Application to Discharge Condition 5 & 6 of planning permission

I write, for and on behalf of my client, with respect to the grant of planning permission for the *'Permanent siting of temporary seasonal horticultural worker accommodation (8 mobile homes & 3 retrospective mobile homes), hardstanding & service building'* at The Green House Sussex Ltd, Pollard Nursery, Lake Lane, Bognor Regis, PO22 0AD, issued in Decision Notice dated 05 March 2021 (application ref: Y/151/20PL).

For and on behalf of my client I now submit an application for the discharge of Condition 5 & 6. As you are aware, the previous applications to discharge Condition 5&6 have been refused. The most recent application (Y/139/21/DoC) was refused in Decision Notice dated 16 November 2021.

GRAVEL SURFACE SECTION
(NTS)

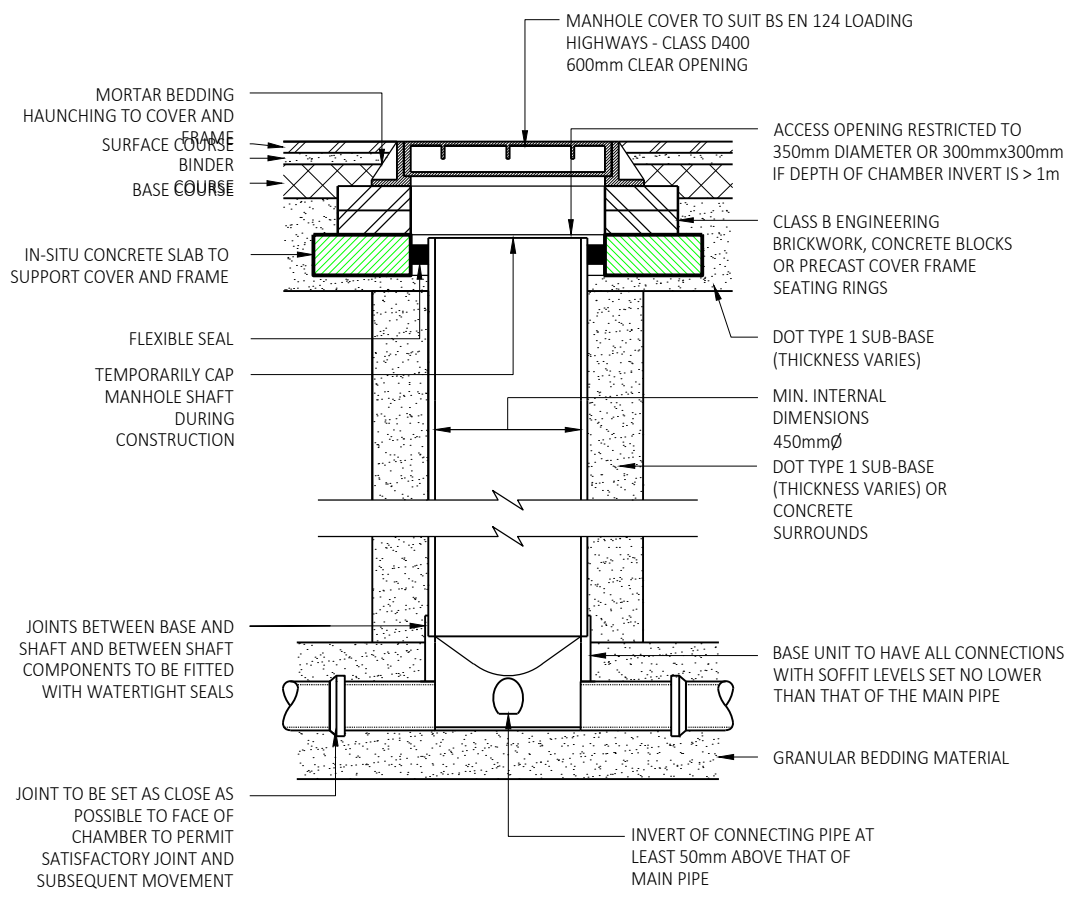
- *'The headwall drawings should show the setting of the headwall, i.e. include bed and bank, and bank profile.*
- *The sub-base depth under the caravans is still stated as 200mm.*
- *As an absolute minimum a land drainage consent application should be submitted prior to determination of this application.'*

In response, the enclosed drawings have been updated to address the Drainage Officer's concerns. Drawings comprise:
